**Re: Comment Letter for Proposed Redevelopment of 6950 SE Maker Street  
Permit No. 2207-019**

On behalf of our client, Dan Grove, we submit these comments on the permit application for the proposed demolition and rebuild of the home located at 6950 SE Maker Street (the “Strand Property”) pending under Permit No. 2207-019 (the “Permit”). Mr. Grove owns the house immediately adjacent to the east of the Strand Property and is acutely familiar with the issues discussed in this letter. Mr. Grove respectfully requests notice and a copy of the permit decision once made by the City.

TOPOGRAPHIC & BOUNDARY SURVEY
PARCEL NO. 9350900620

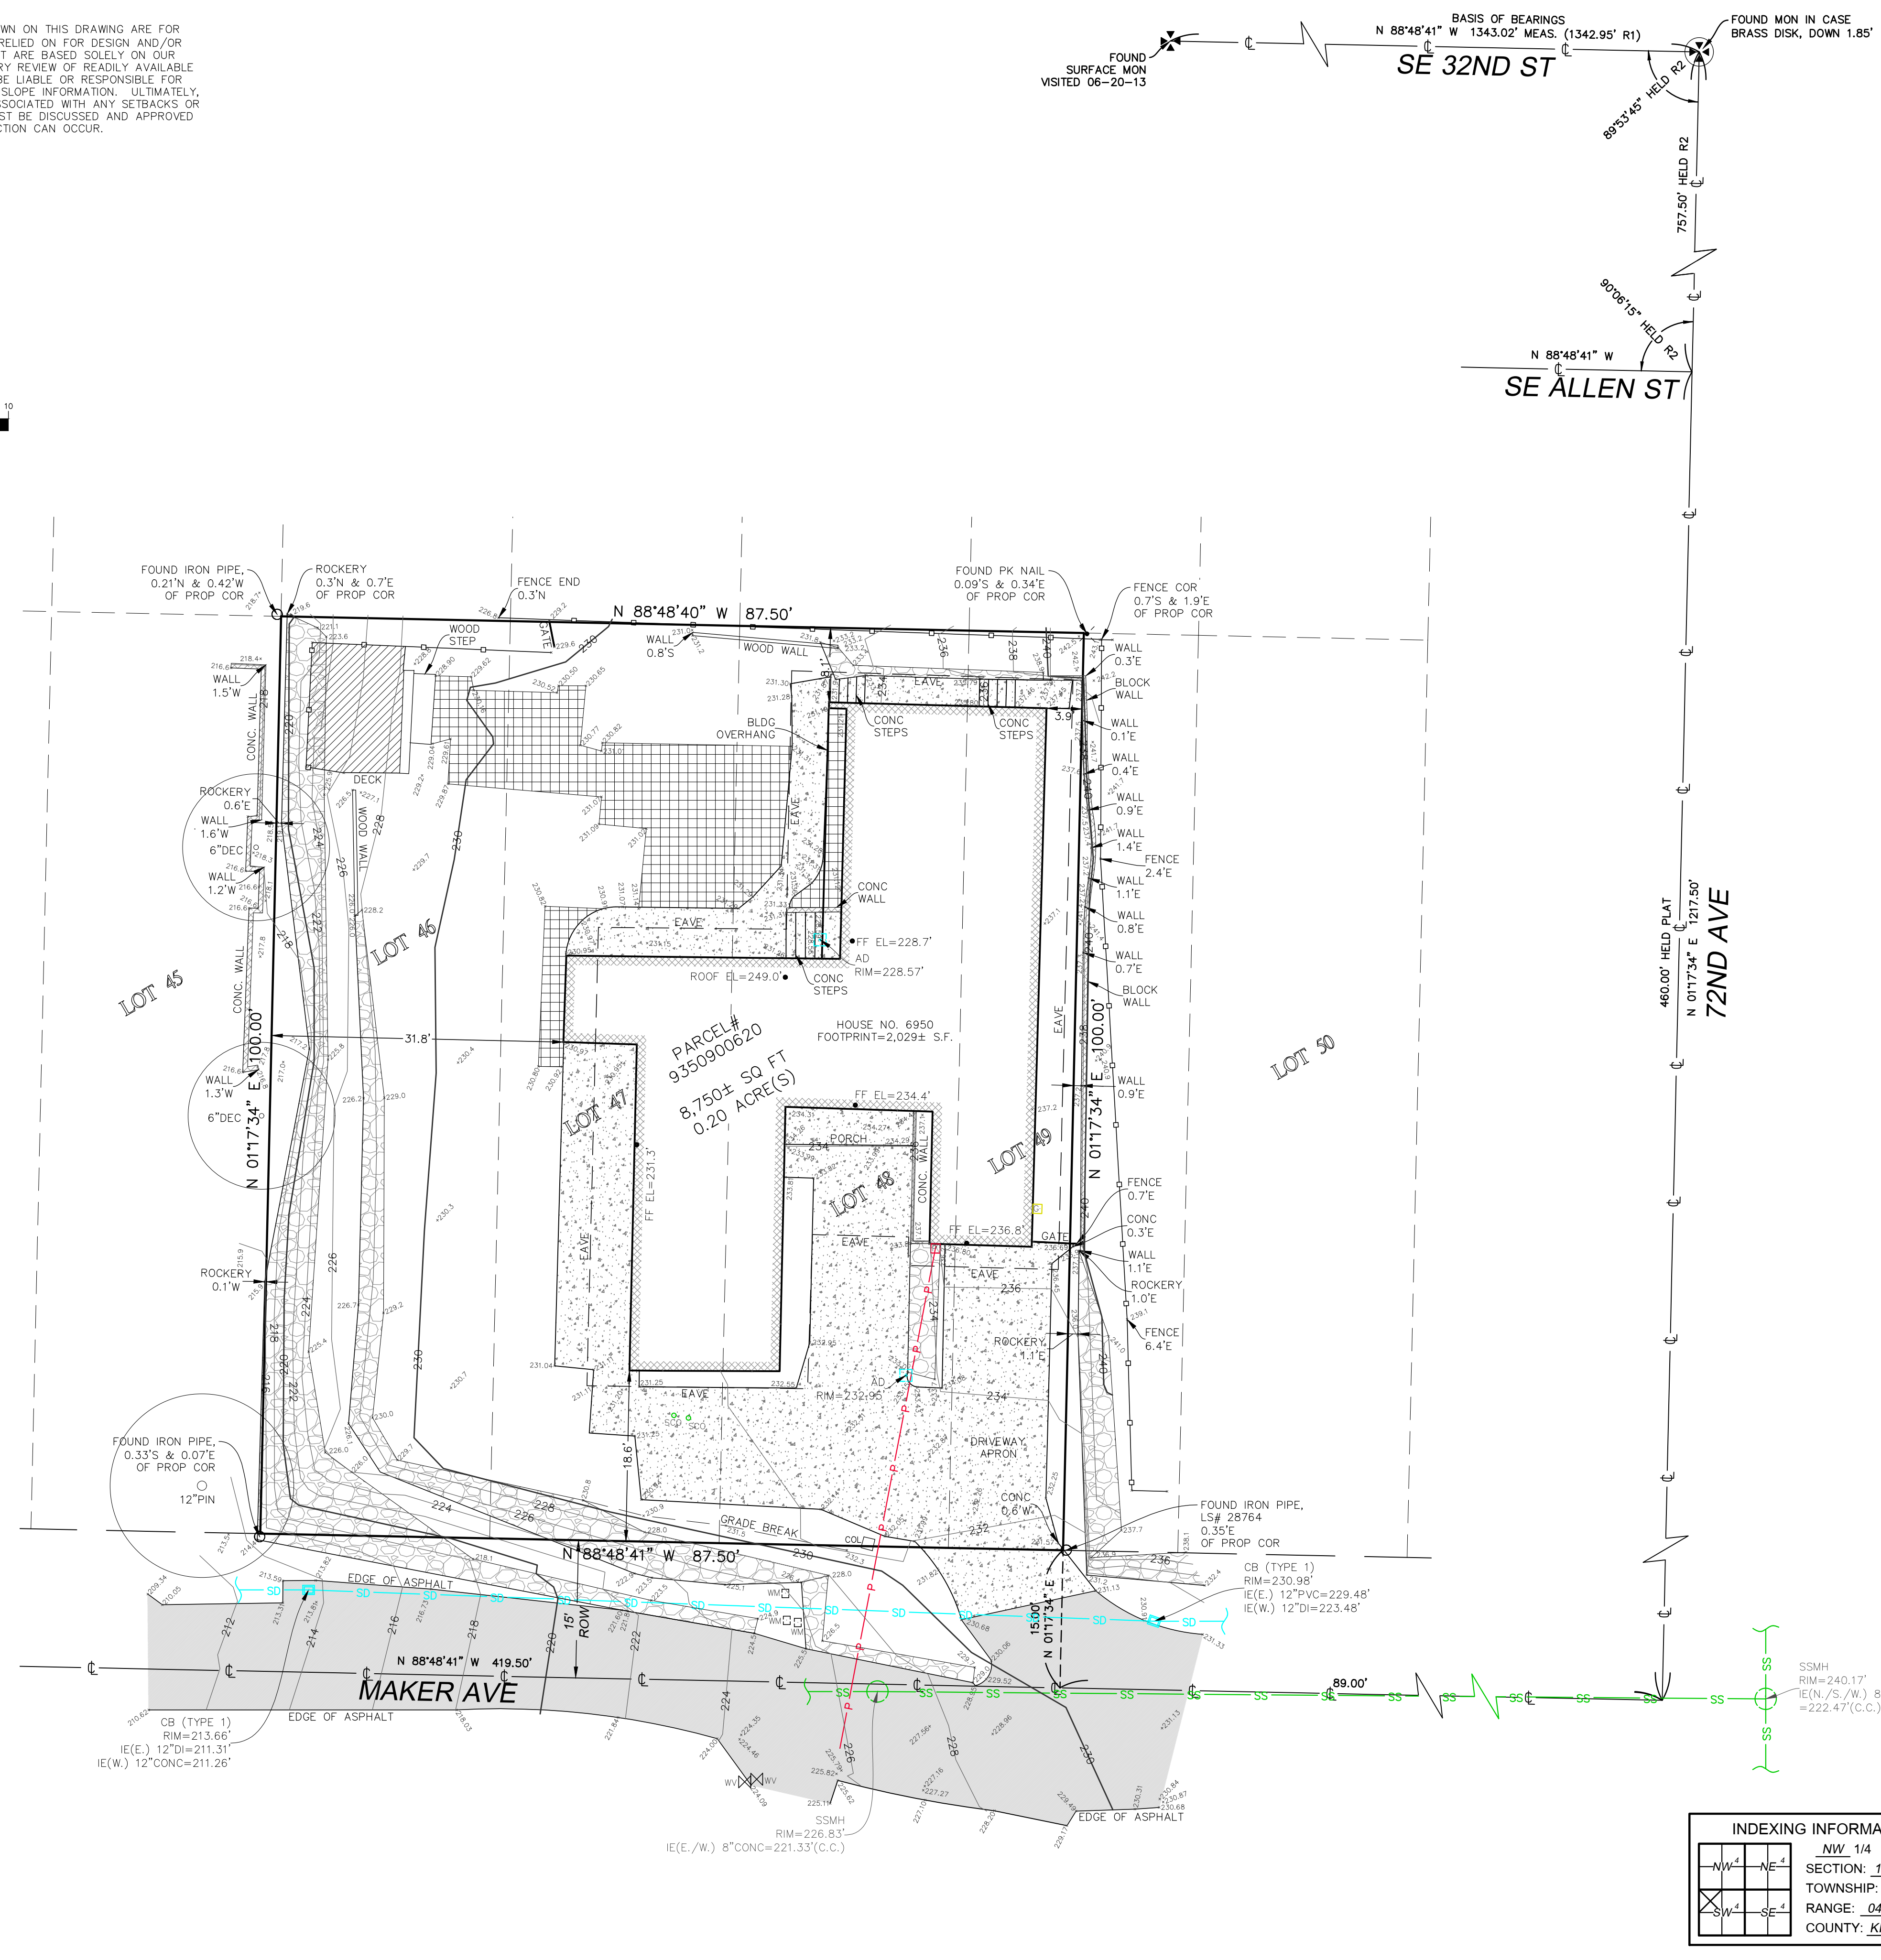
finished floor elevation of the basement as 228.7' (Sheet 1), the proposed finished floor elevation as 227.72' (Sheet C-2), and the existing grade as 235.24' (Sheet A3.1).

The existing grade of the lot slopes down primarily from east to west in line with the slopes shown in the 7145 Survey (Exhibit A). The corner elevations below are the result of using the interpolated contours from Exhibit D and Exhibit E. The table below compares data from Exhibits A through E, and shows that the existing elevation of the proposed structure is closer to 226.6'–226.75'.

BASEMENT PLAN

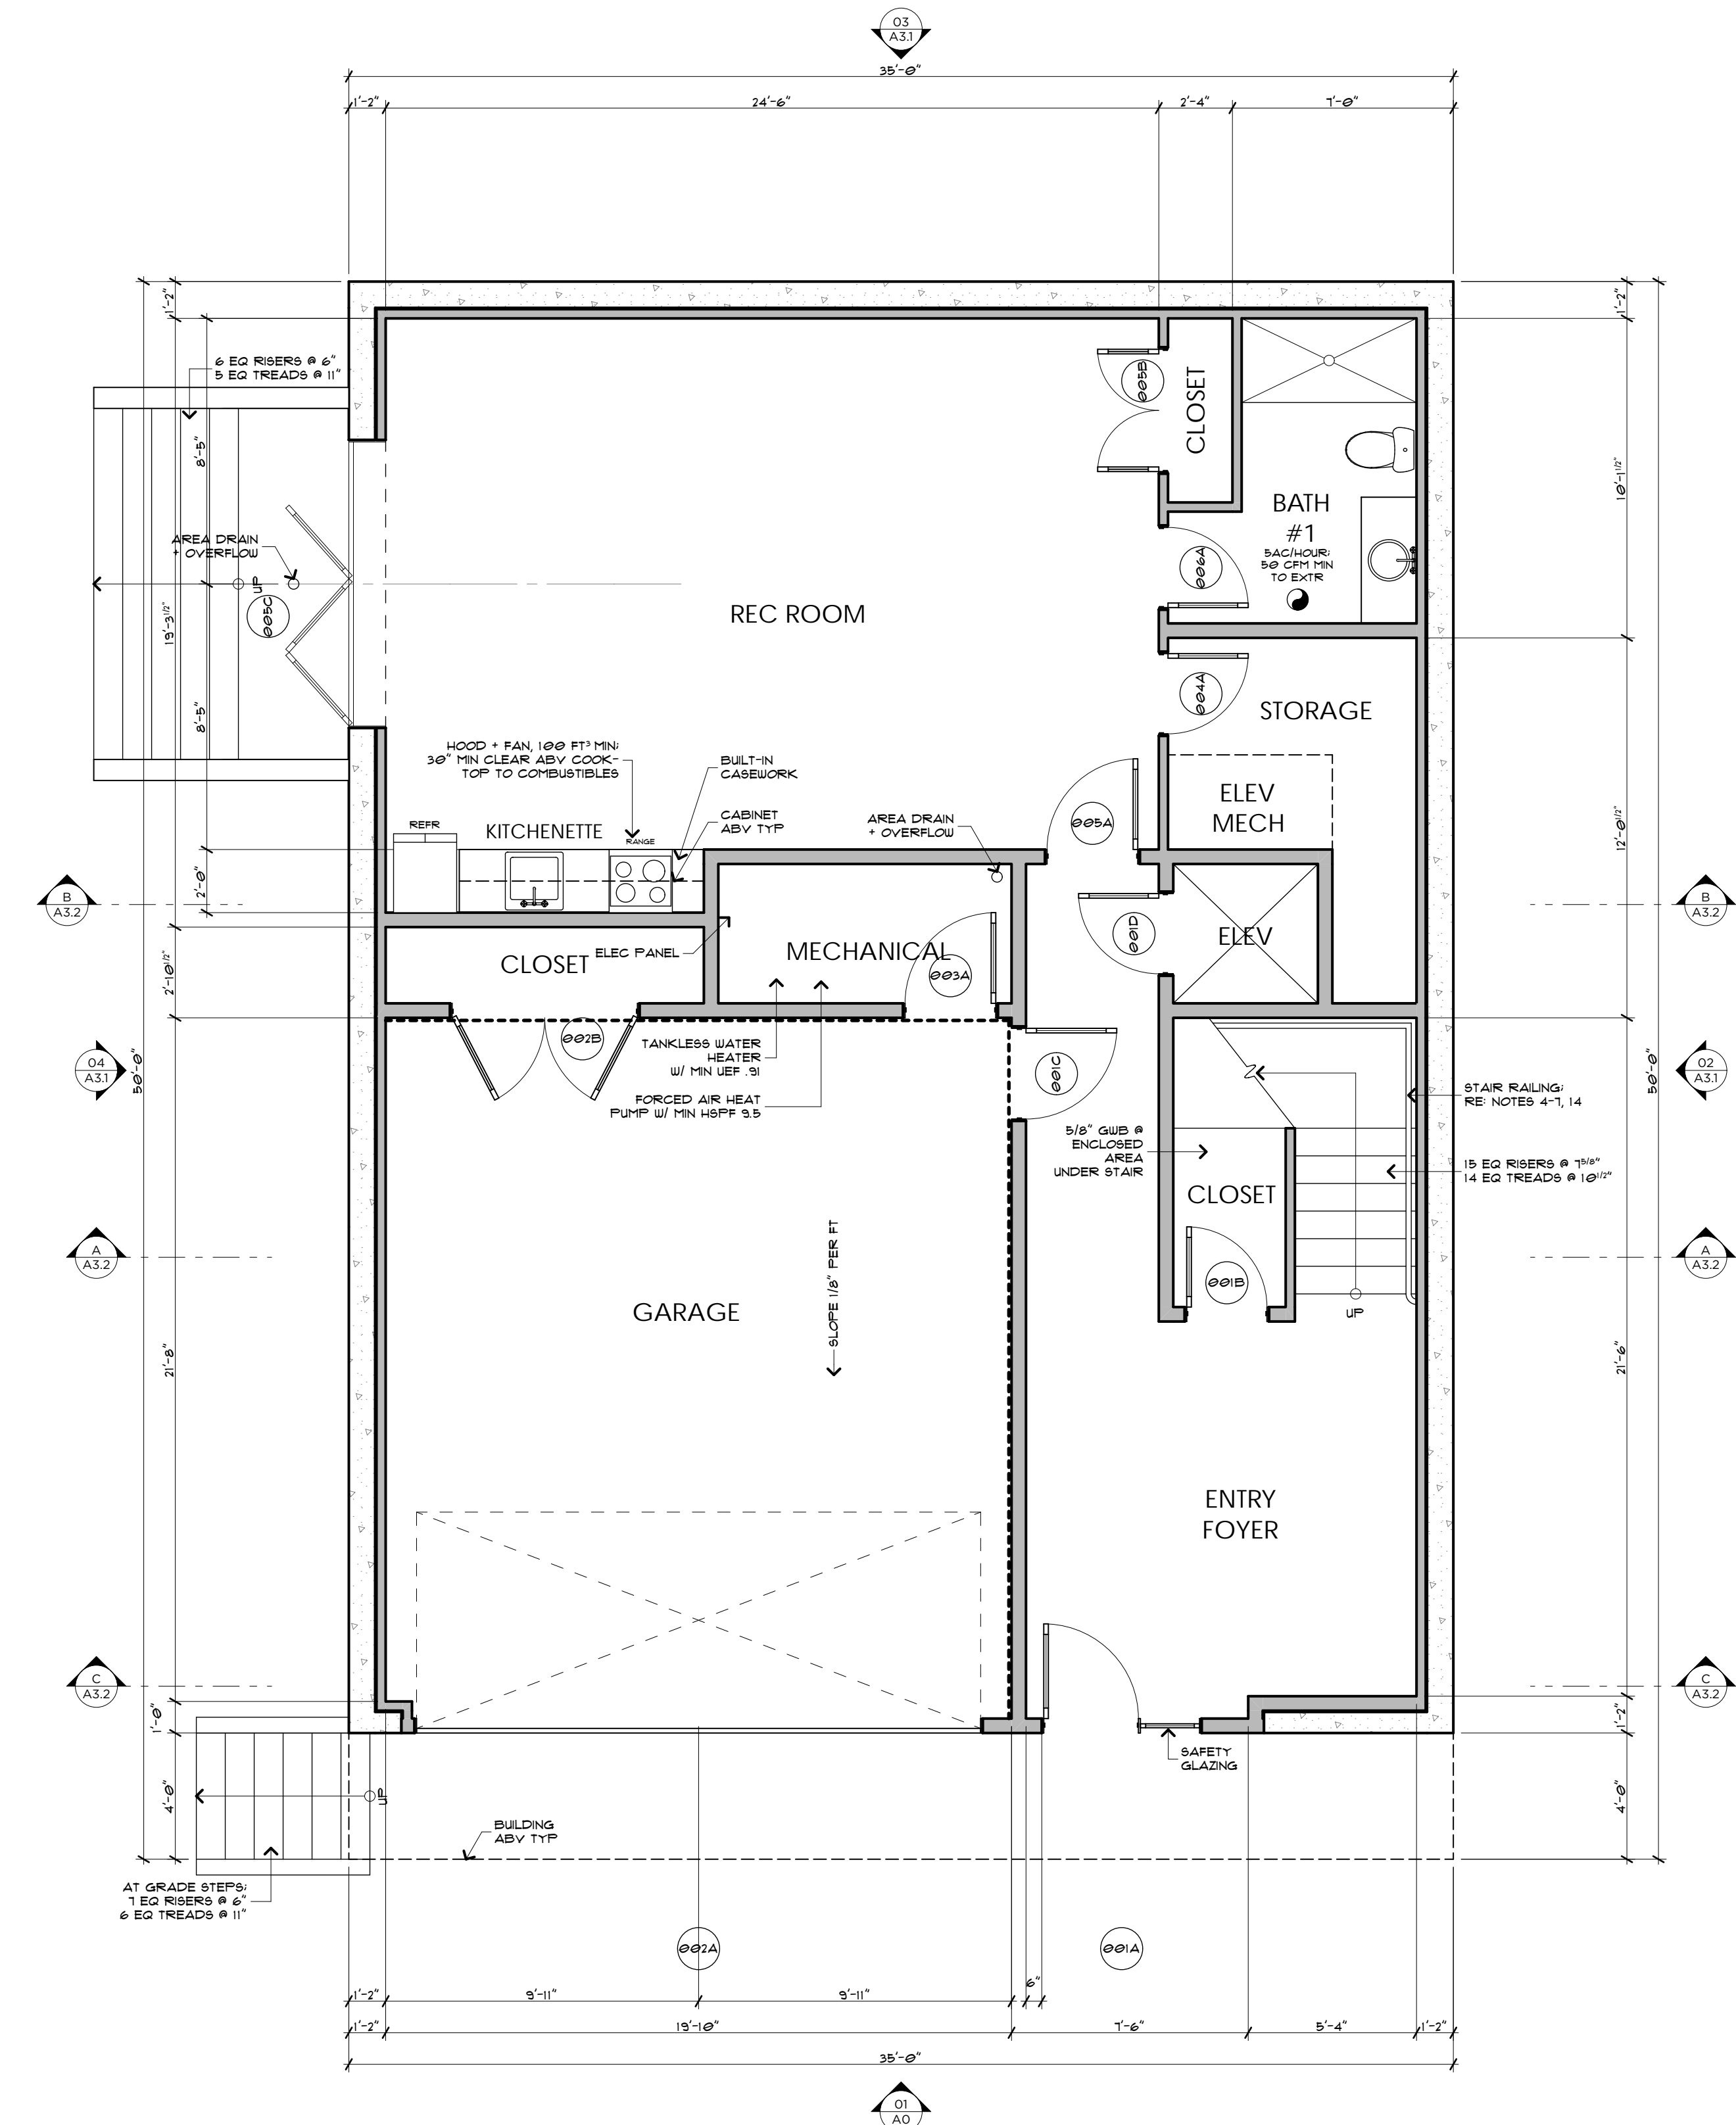
The Site Development Information worksheet and Plan Sheet A1.0 identify the following:

Area	Square Footage
Upper Floor	1,686 sq. ft.
Main Floor	1,750 sq. ft.
Decks	62 sq. ft.
Basement and Garage Area (excluded)	1,575 sq. ft.
Total GFA (w/exclusions)	3,498 sq. ft. (39.9%)

This information incorrectly excludes the full basement area. The Mercer Island Development Code does not allow the total basement area to be excluded out-right, as the Permit applicant did

The applicant does not appear to have provided such calculation in the Permit materials. As a result, the proposed elevation and grade for this development are not accurate, and the GFA contribution from the basement is actually higher than described. We calculate the GFA contribution is roughly 1,293 square feet, making the correct Gross Floor Area closer to 4,791 square feet. This exceeds the 3,500 square feet permitted by the Code.
